DELEGATED DECISION TO DETERMINE PLANNING APPLICATIONS

Reference No:	2026/62/92141/W
Site Address:	33, Hadrian's Close, Salendine Nook, Huddersfield, HD3 3XZ
Description:	Demolition of existing conservatory and outbuilding and erection of two storey side and rear extension
Recommending Officer:	James Evans

Officer Report – 2026/92141

SITE BLOCK PLAN 1:200

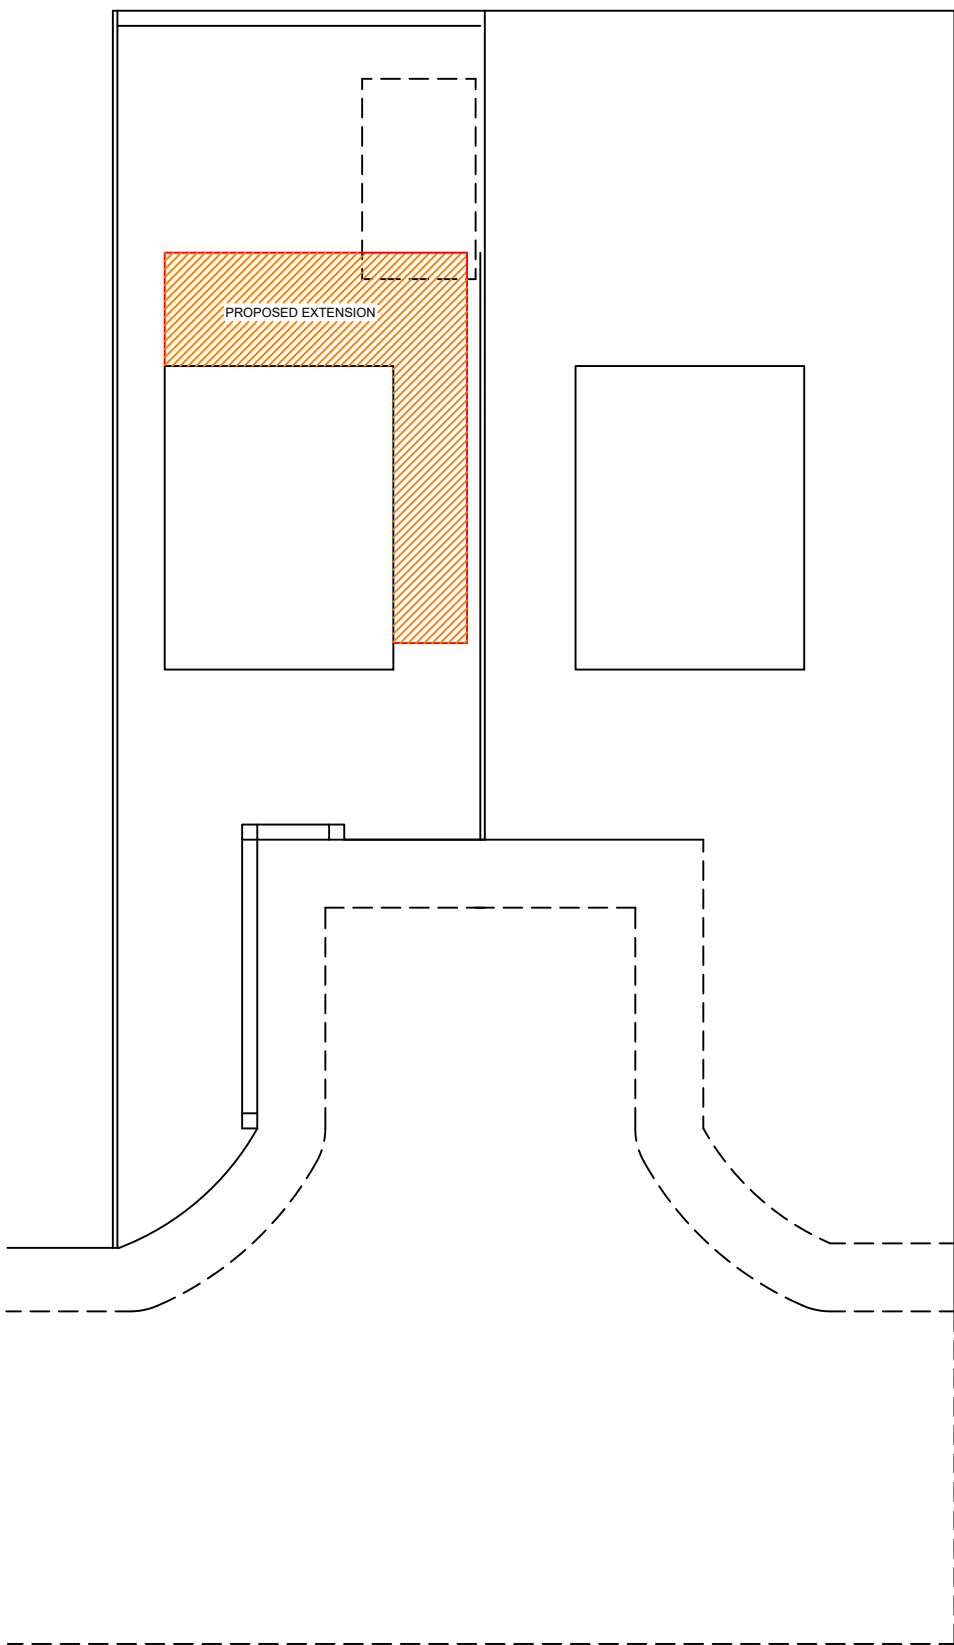
No amendments have been requested by Officers. However, Officers requested further information from the applicant regarding the proposal, including a block plan of the proposal, and requested a 45 degree line to be drawn on the plans from the nearest habitable window. The applicant responded to this request and Officers were satisfied with the information provided.

DRAWING TITLE:
PLANS AS PROPOSED

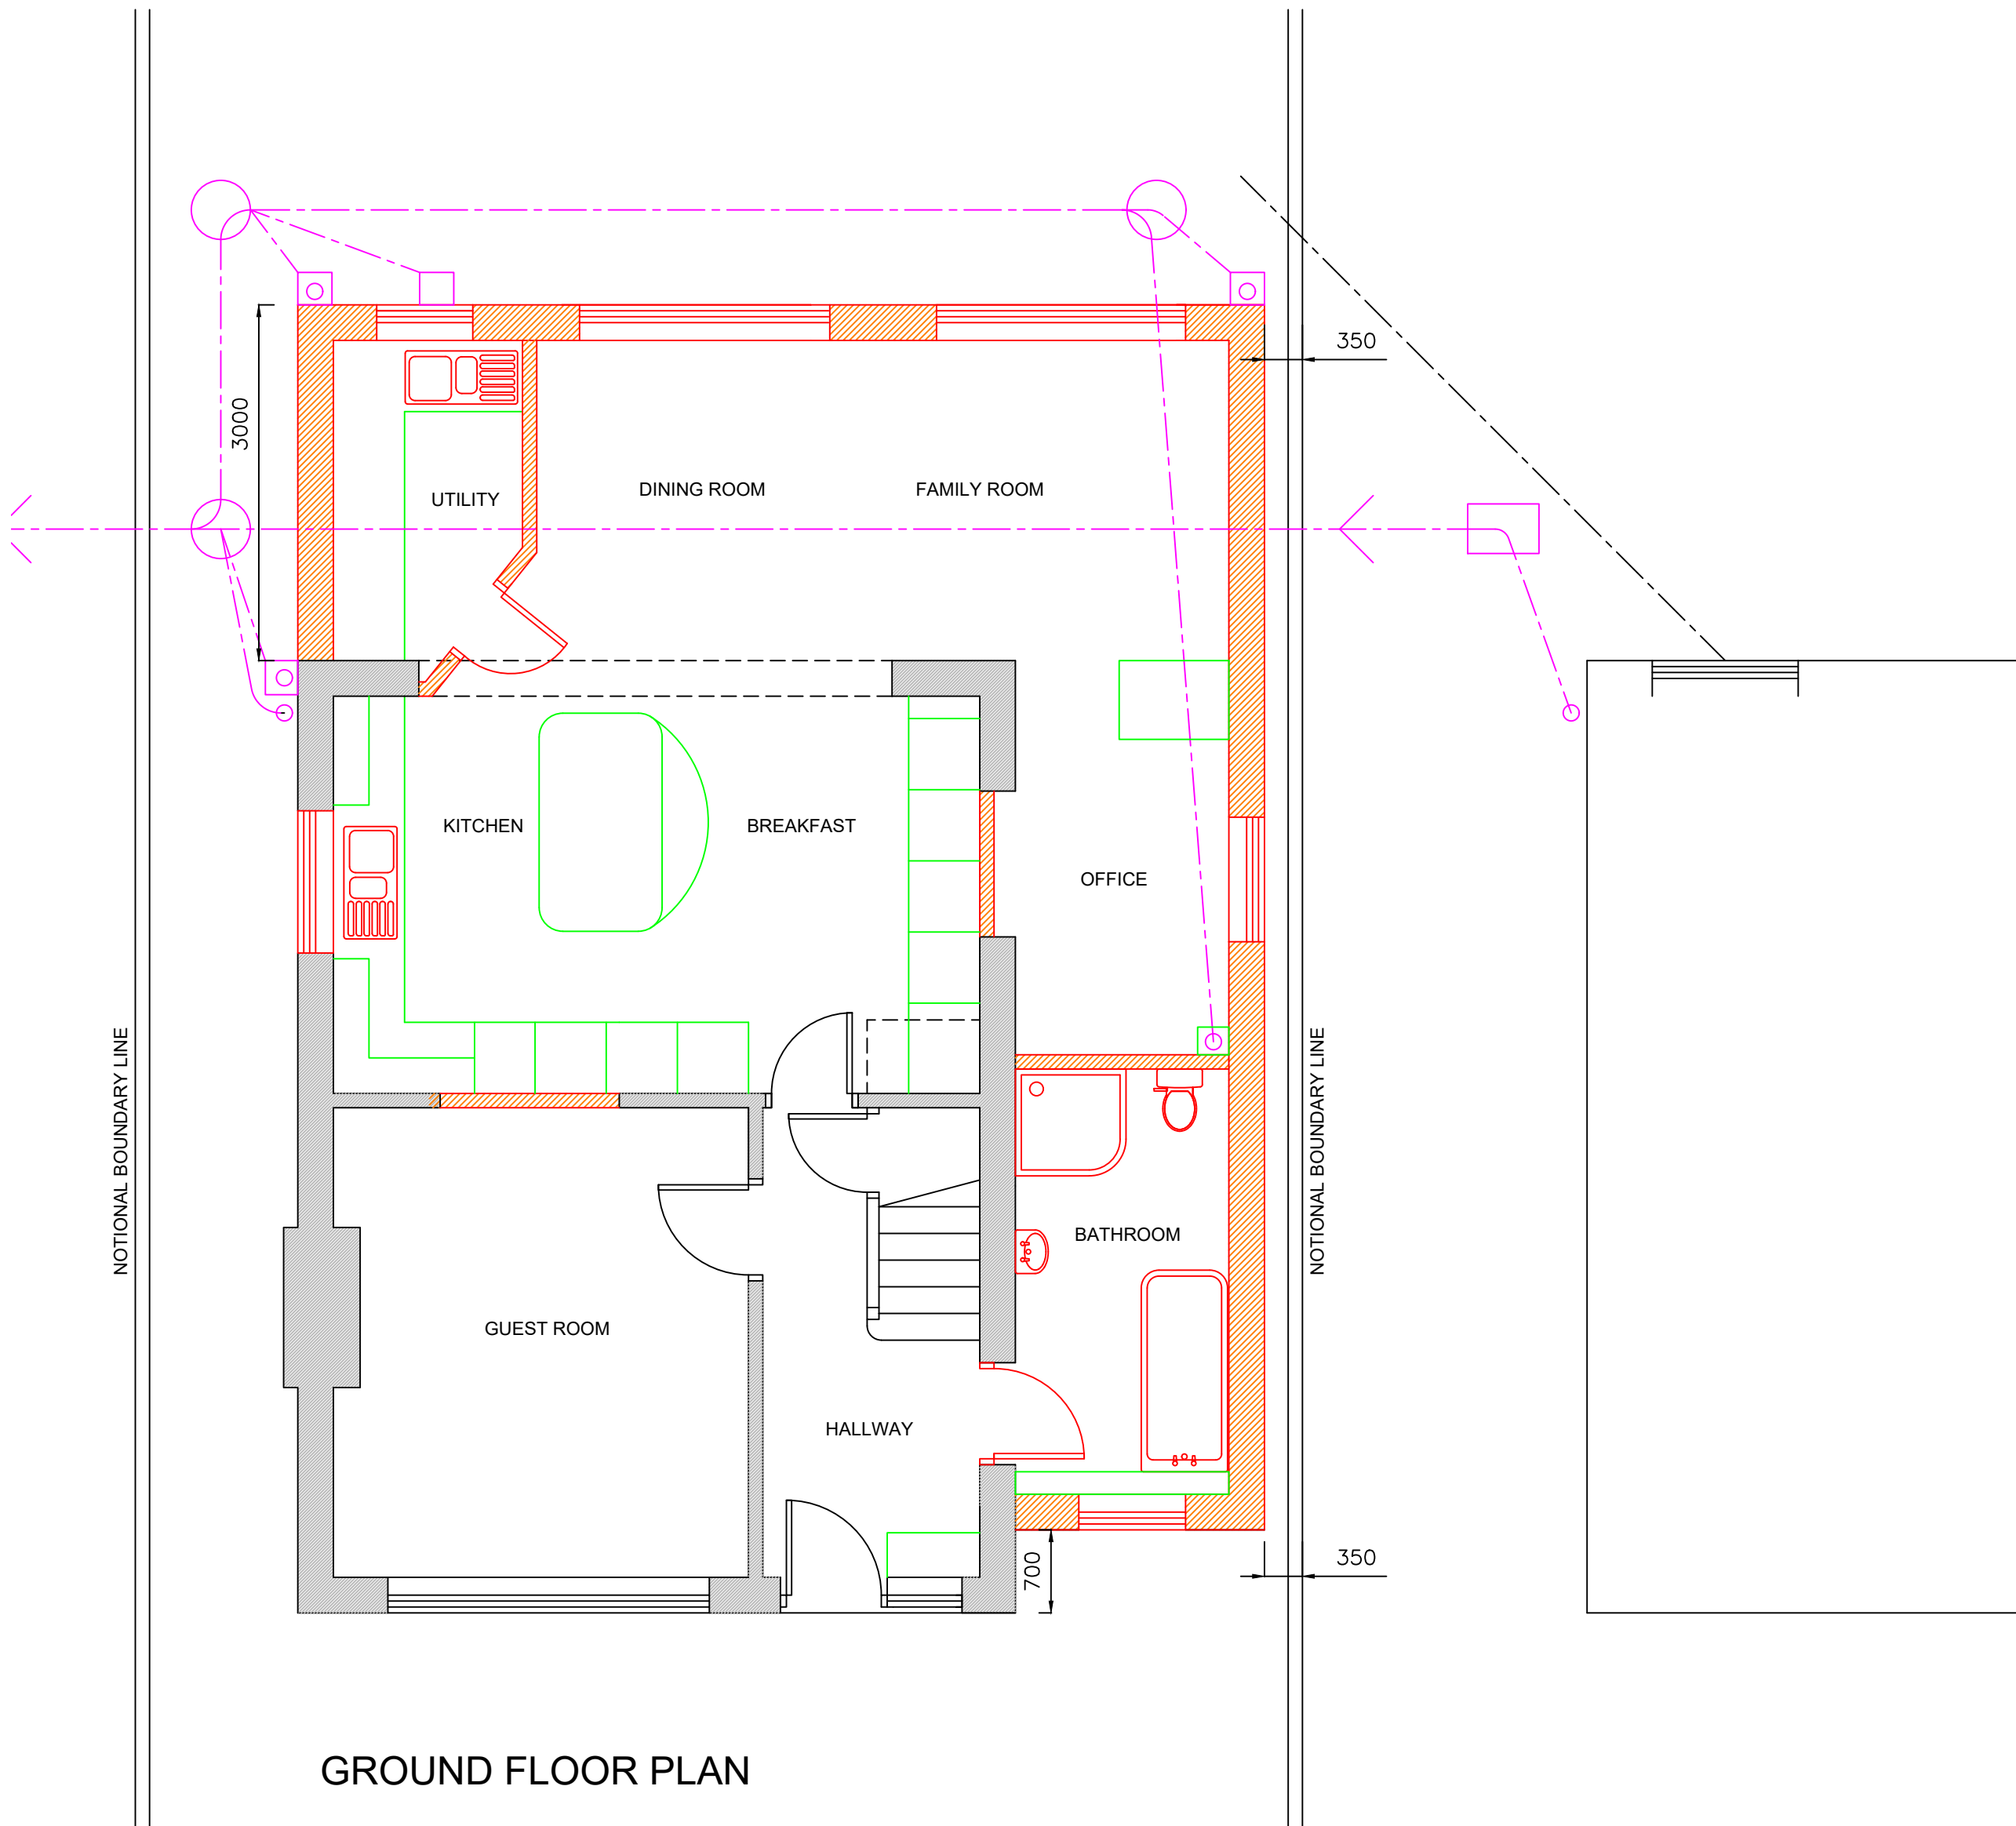
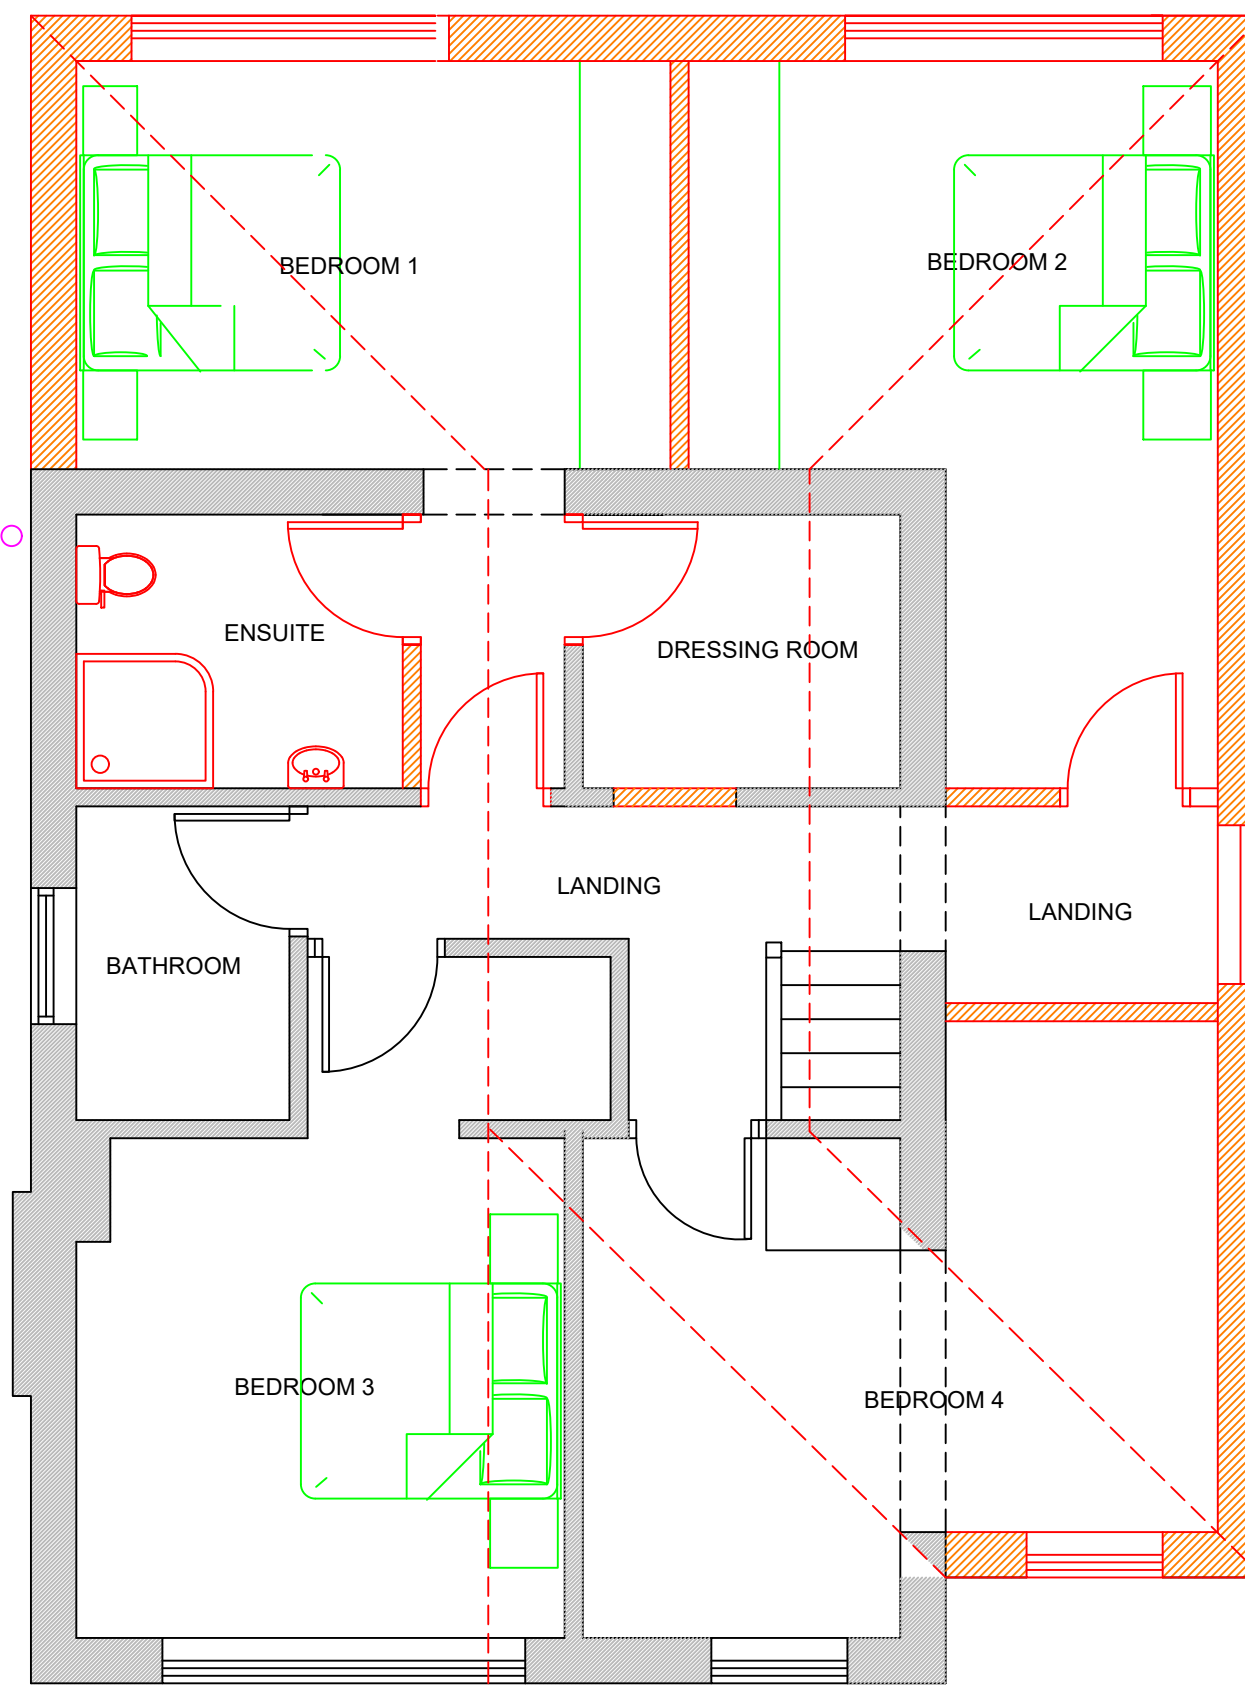
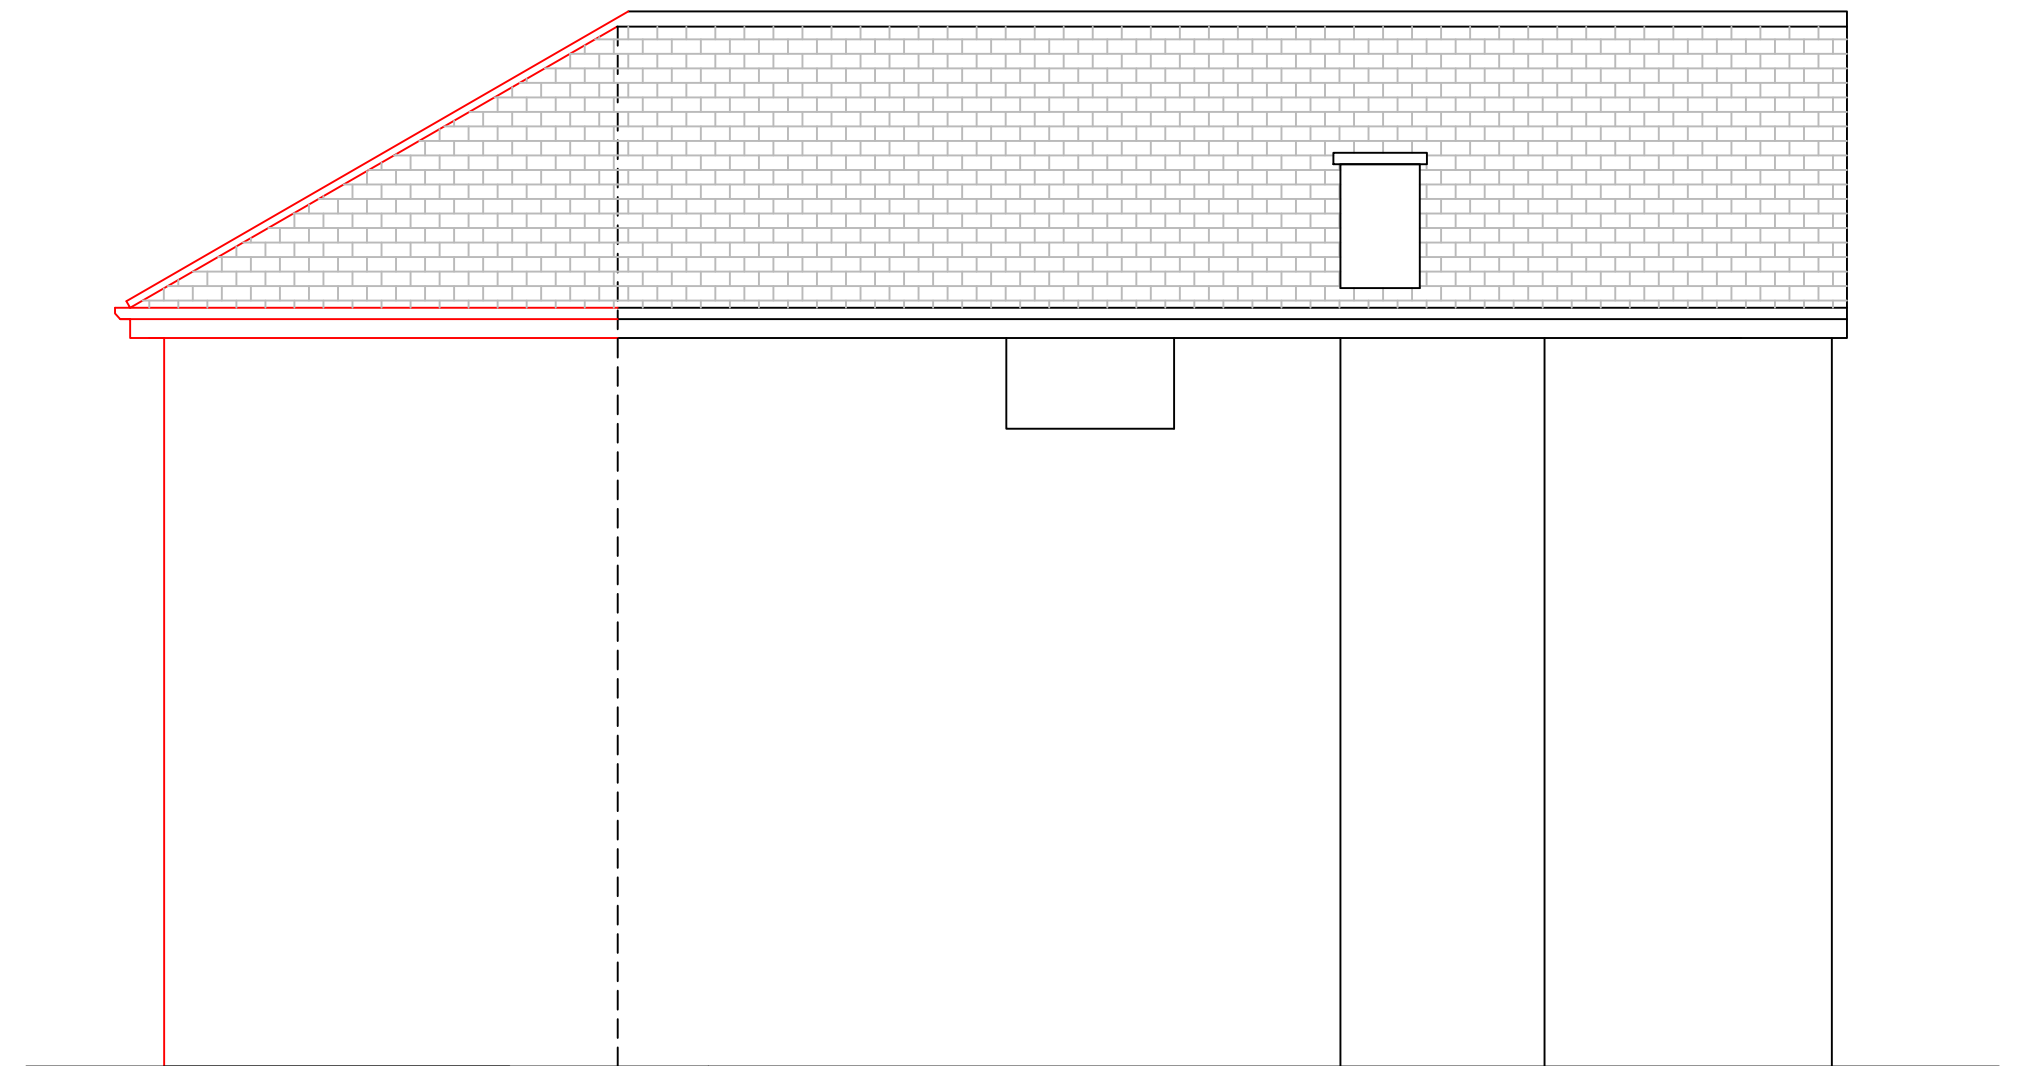
The two-storey side extension will be set back 0.7m from the front elevation of the host property, and will project 2.1m from the existing side extension. However, the side extension will decrease the gap to the shared boundary with 35 Hadrian's Close to 0.35m, in a departure from the SPD. This departure is considered acceptable on balance due to the previously approved proposal (2016/93097), which granted planning permission for a smaller gap to the boundary.

With regard to overlooking, there are two proposed openings in the north facing elevation of the extension, however these are high level windows that will have limited overlooking impact on 35 Hadrian's Close.

With regard to overshadowing, it is noted that the proposal is larger in scale than the previously approved application, importantly the proposed extension projects further along the shared boundary than the previous proposal. This may cause additional overshadowing in the early hours but it is noted that the area affected is mostly taken up by the existing outbuilding at 35 Hadrian's Close. Additionally, the proposal passes the 45 degree rule, so is considered acceptable in this regard. In terms of overbearing, it is considered that an acceptable degree of openness remains at 35 Hadrian's Close, particularly to the west and north.

The two-storey rear extension is the aspect of this proposal considered most relevant to 31 Hadrian's Close. There are no concerns regarding overlooking as there are no proposed openings in the south facing elevation of the proposed extension. It is acknowledged that the proposed would increase the built form of the host property when viewed from the rear of no.31, however the extension is located to the north and it is not considered that it would lead to a detrimental overshadowing impact to the occupiers of no.31. Any potential overbearing impact is mitigated by the considerable separation distance between the properties and the existing outbuilding at No.31.
